**LETTER OF INTENT
FINAL PLAT CORRECTION - NOTE AMENDMENT REQUEST – THE GLEN AT
WIDEFIELD FILING NO. 9**

September 4, 2020
Rev. September 9, 2020

PURPOSE: A Plat Correction to amend the note section of the Glen at Widefield Filing No. 9 recorded plat on page 2 of 3 entitled “Areas of High Ground Water” to add updated Geological Hazard information about new studies that will show that the high ground water issues have abated within the respective lot area and that the restriction to not allow basements on lots 87-90 can be removed.

THE GLEN AT WIDEFIELD SUBDIVISION FILING NO. 9 PLAT NOTE AMENDMENT

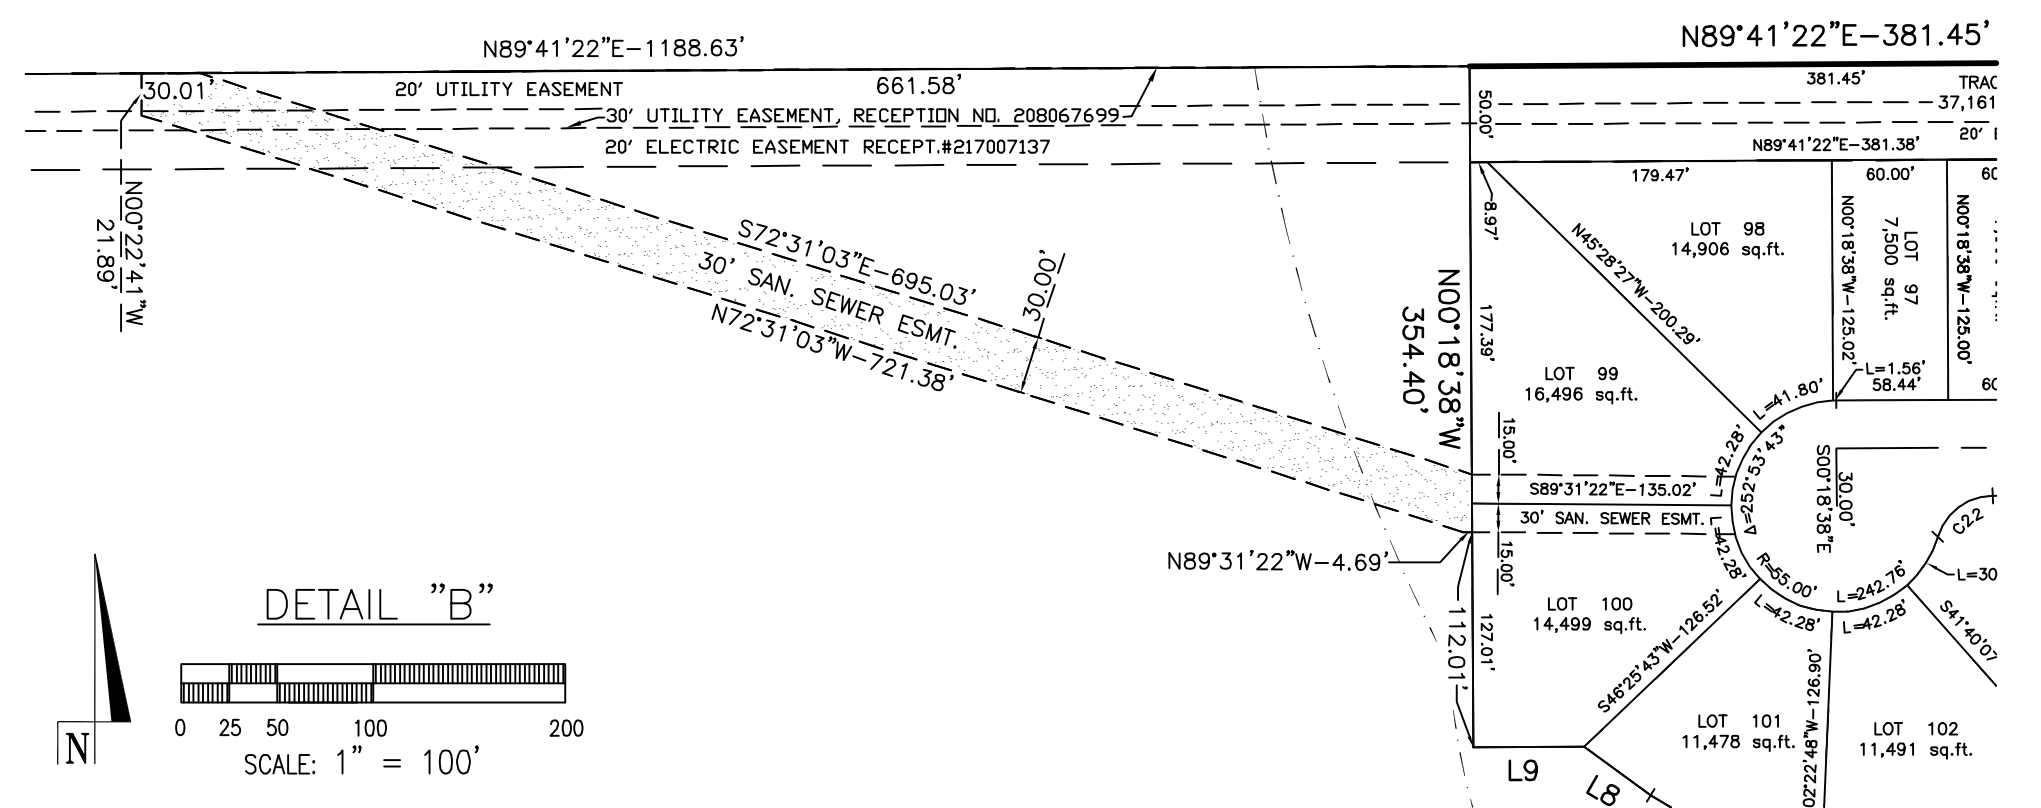
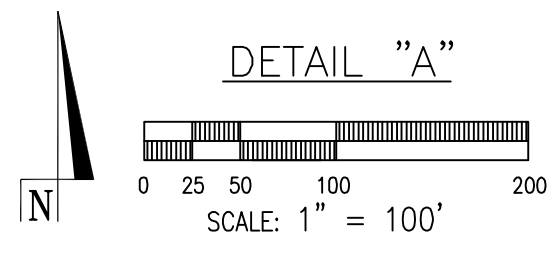
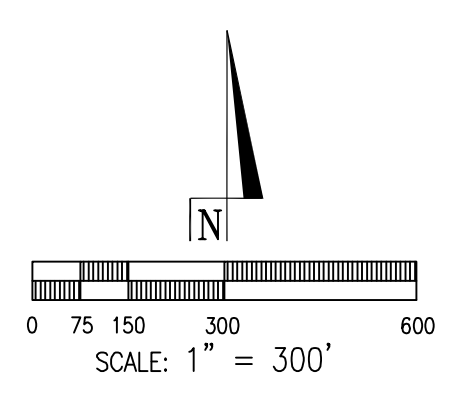
Additional studies have now been performed and prepared by J&K Geological Services on August 3, 2020 and by RMG, Inc on June 19th, 2020. The results of the testing confirmed that the groundwater levels under these respective lots has indeed changed since grading and development has occurred in this area of the Glen. Groundwater levels are now shown at an acceptable depth to allow basement construction on the aforementioned lots. These additional studies and reports are being submitted with this request for a plat correction of note amendment. Two new notes are proposed to be added to the final plat document for The Glen at Widefield Filing No. 9. Those notes can be found in the section entitled “Areas of High Groundwater” on sheet 2 of 3. The notes to be added are as follows:

“Some areas of the proposed development will be impacted by geologic hazard, including the presence of both expansive and hydrocompactive soils. Mitigation measures and a map of the hazard area can be found in the report prepared by RMG, Inc. prepared on June 19, 2020. Additional studies and mitigation recommendations can be found in a study prepared by J&K Geological Services on August 3, 2020.”

“Previous reports conducted by STE, Inc. and Hepworth-Pawlak had showed areas of high groundwater in the area of lots 87-90, however recent investigations by RMG, Inc. in June 19, 2020 and by J&K Geologic Services in August 3, 2020, show that groundwater levels are at an acceptable level to allow development of these lots with foundations and basements as long as the builder adheres to recommended mitigation procedures within the related studies.”
